**Town & Country Planning Act 1990 (as amended)
Town & Country Planning (Development Management Procedure) (England) Order 2015
Application for Planning Permission for Works or Extension to a Dwelling**

Development removing tiles to existing outside front and left side of bungalow and replacing with cladding see quotation from Square Deal attached to application
Location 12 White Horses Way Littlehampton

12, White Horses Way, Littlehampton, West Sussex, BN17 6NH

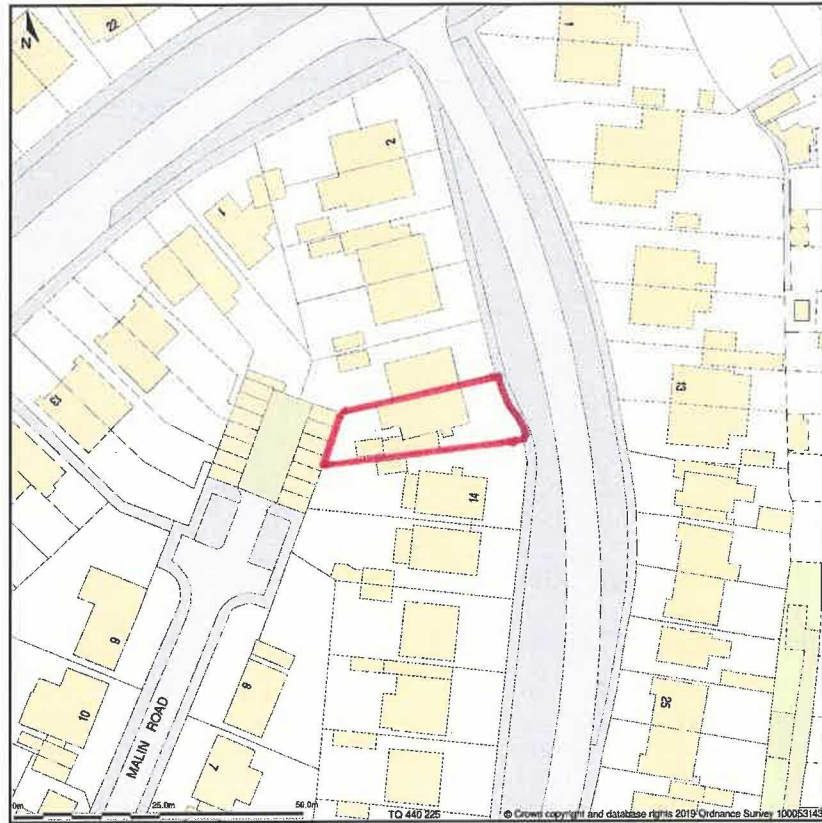
Location Plan: You are required to have a solid red outline around the proposed site on the location plan. Please amend.

*Proposed Front
+ side elevation.*

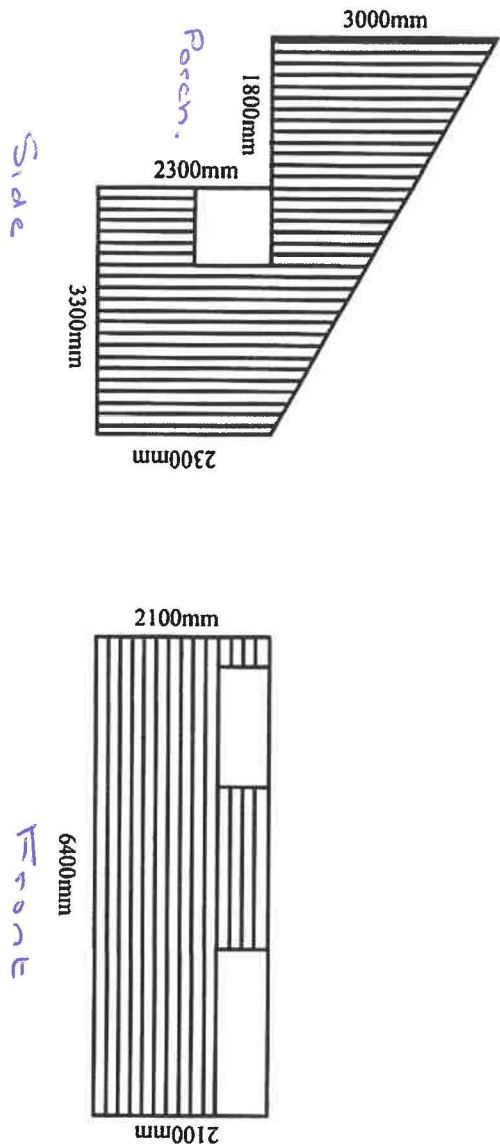
Elevations: Please submit proposed and existing scaled elevations with annotations to show the change in materials to the elevations. Please submit these at a standard scale such as 1:50 or 1:100
